**From:** Hughes, James D.  
**Sent:** Friday, February 02, 2018 12:54 PM  
**To:** 'David Soule'  
**Cc:** Peterson, Dana M.; Adeeb, Muhanned W; Wolfenbarger, Jeanne; Elliott, Stanice  
**Subject:** RE: Sunset K12D003

The attached letter approving the Engineer's certification for release of Financial Guarantee may have been premature. The Certification shows the pads were constructed at the planned elevations and further states that the lots drain according to plan, but if the street was constructed higher than planned then I don't see how the lots can drain to the street. The easiest way to resolve this issue is to add the property corner elevations to the certification and resubmit it. Is that something that you can do?

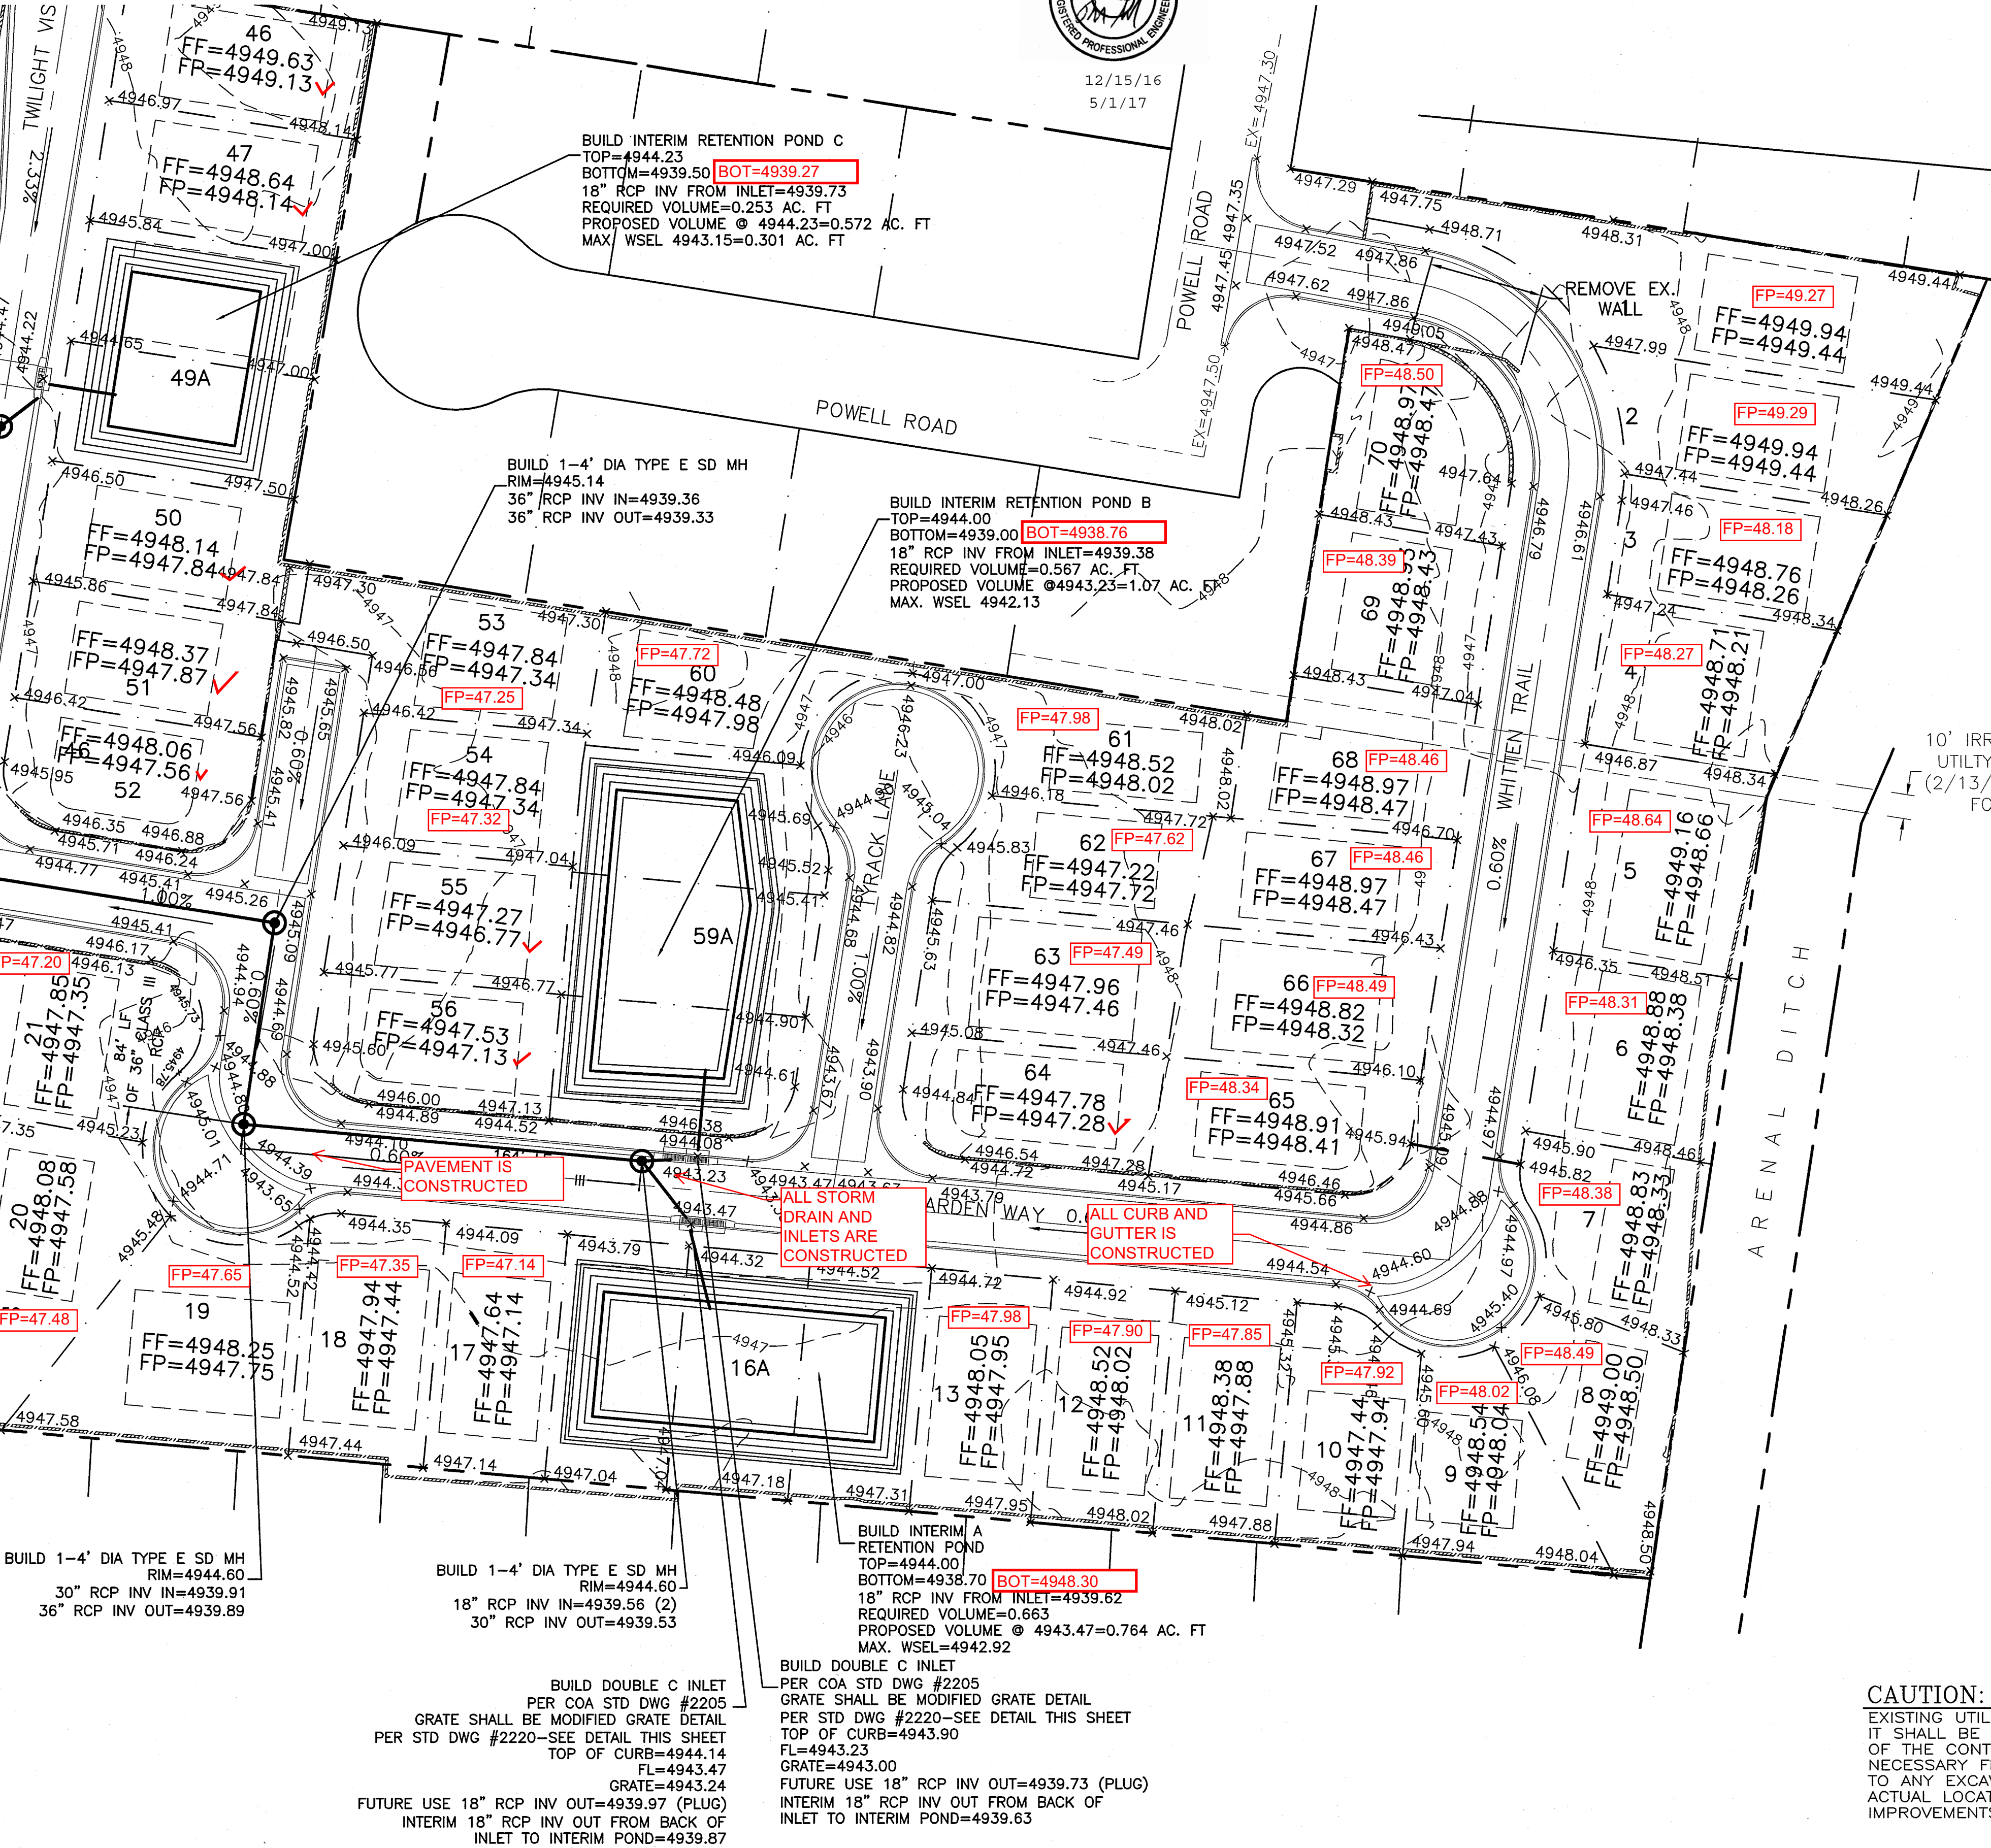
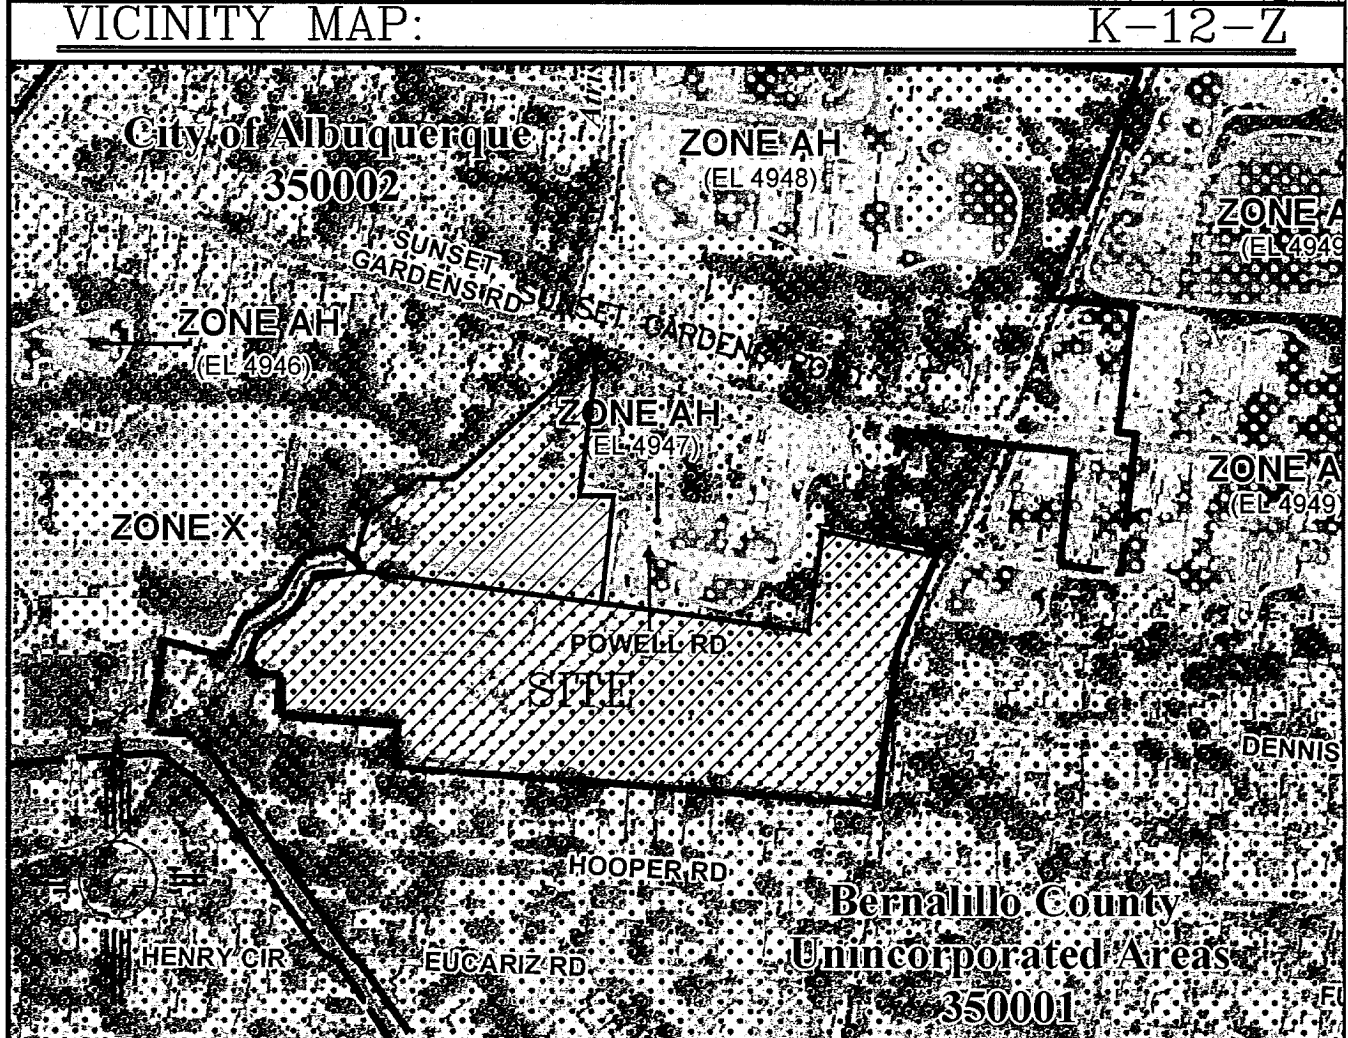
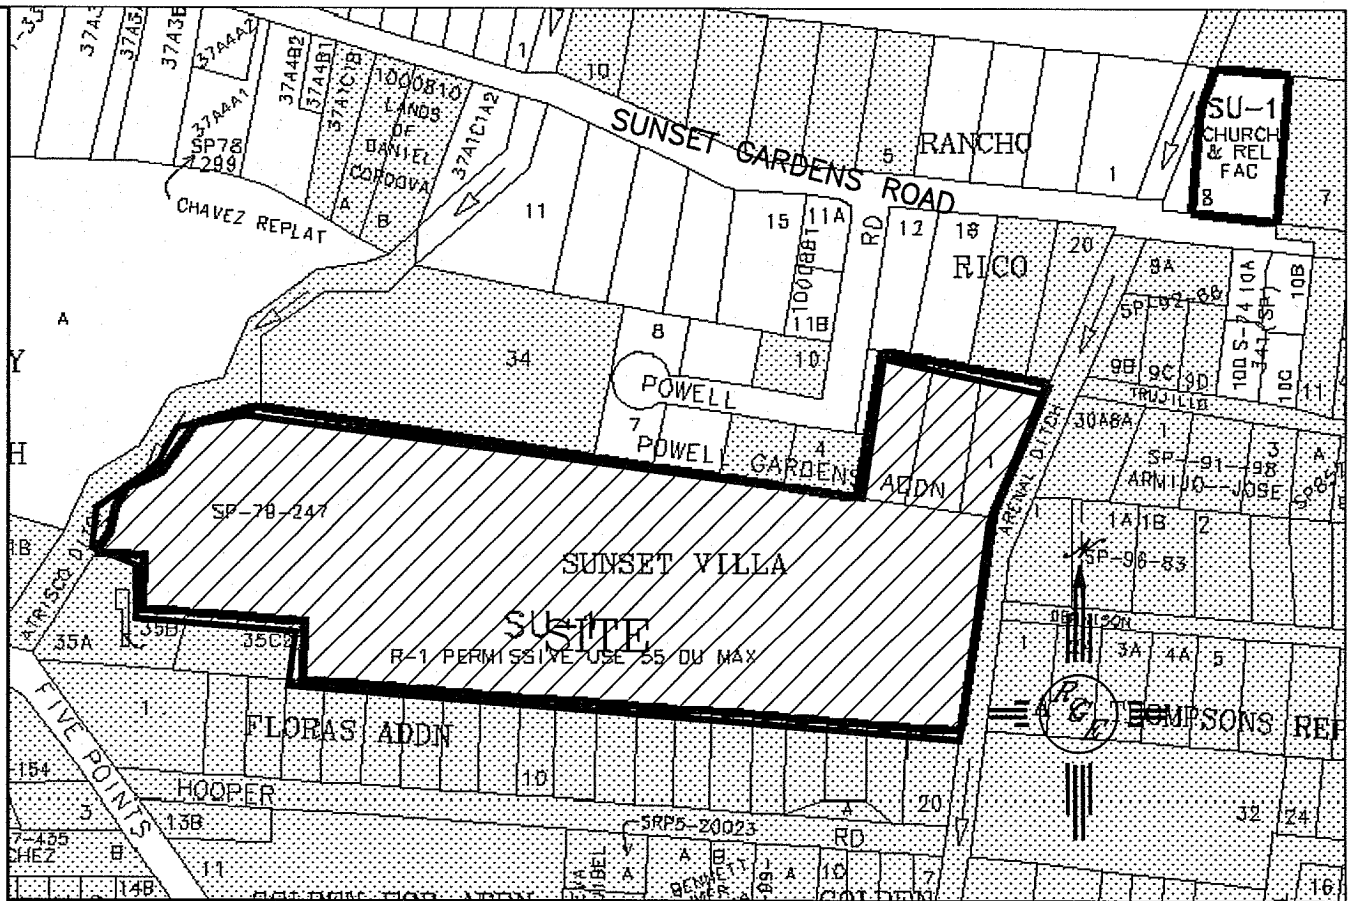
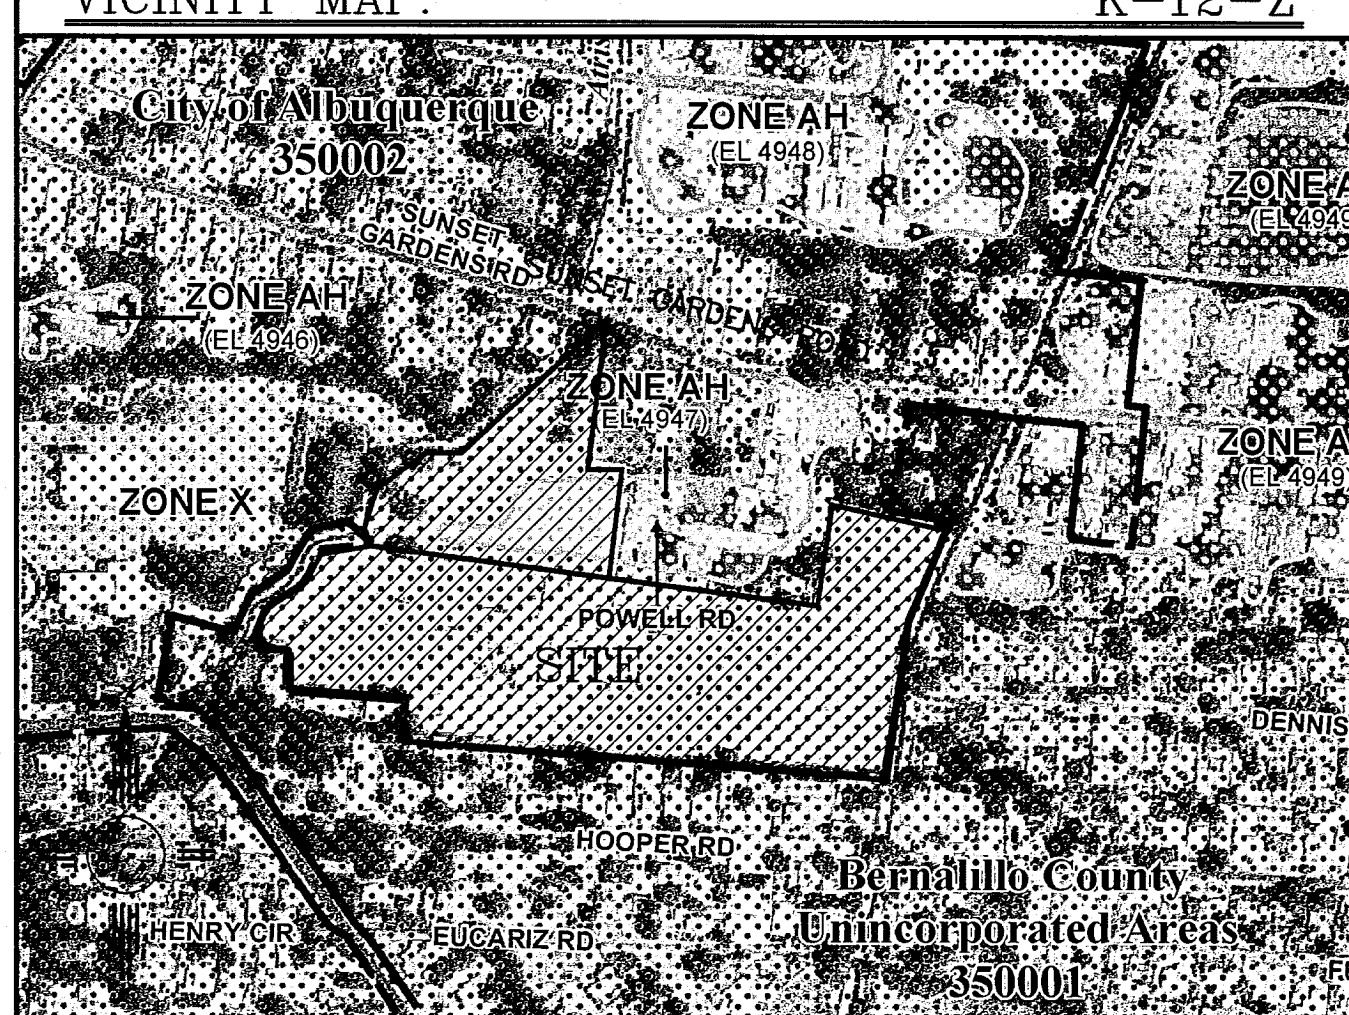
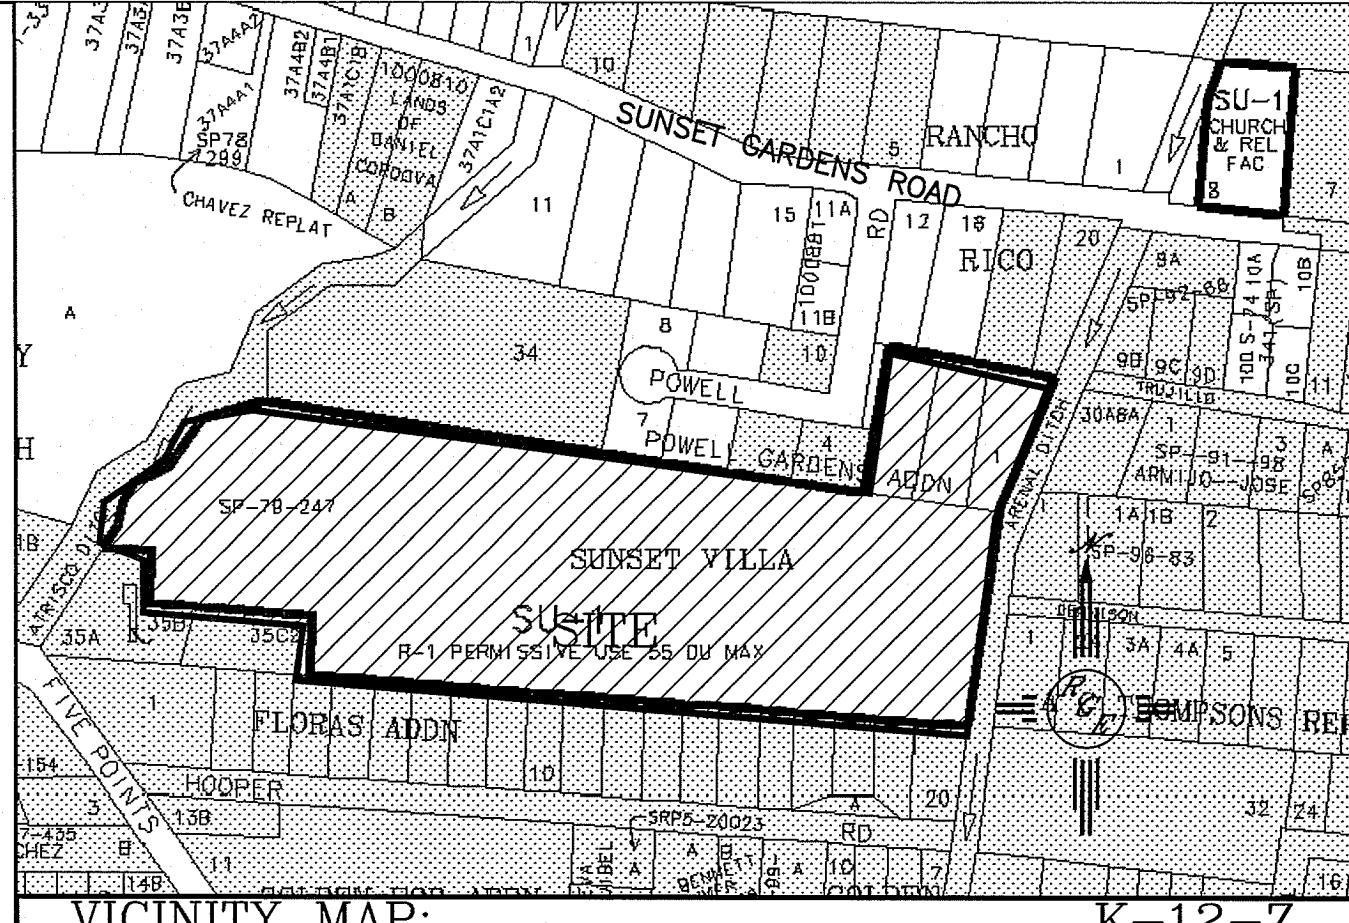
Apparently someone changed the street grades, and this sort of change must be made by formal request to hydrology before it is constructed. It seems to me that whoever made the decision to make that change without informing hydrology is the one responsible for the cost now, to include any infrastructure we find unacceptable and needing to be replaced. The missing property corner elevations are required by the DPM as part of the engineer's certification, so please provide a complete certification. The certification should identify the deviations from the approved plan and include a statement as to whether or not they follow the design intent of the plan.

We were not aware until yesterday that the road elevations are typically much higher than what was shown in the design after first submittal of as-builts. (generally a foot higher, some locations are 2 feet higher).

In briefly looking at the FP elevations shown in the attachment, it looks like the FP Elevations are barely higher than roadway grade as opposed to being approximately 2-3 feet higher.

After receiving this email i went thru the files and did another site walk. I dont see what the city is seeing. All the pads are atleast a foot higher than the curbs. The sideyard swales are in (some have blow sand since i certified). I can provide the additional spots as requested, but I believe my certification was appropriate at the time i certified. The site is in substantial compliance to the grading plan. If its not too much trouble a site visit may save my client a few thousand dollars for the additional survey work. I can meet you, or i feel a simple drive thru would be helpfull, Im sorry i dont see the site the same way as the email states. That being said, i always appreciate the opportunity to revisit things, i make mistakes and would prefer to correct them prior to there being an issue.
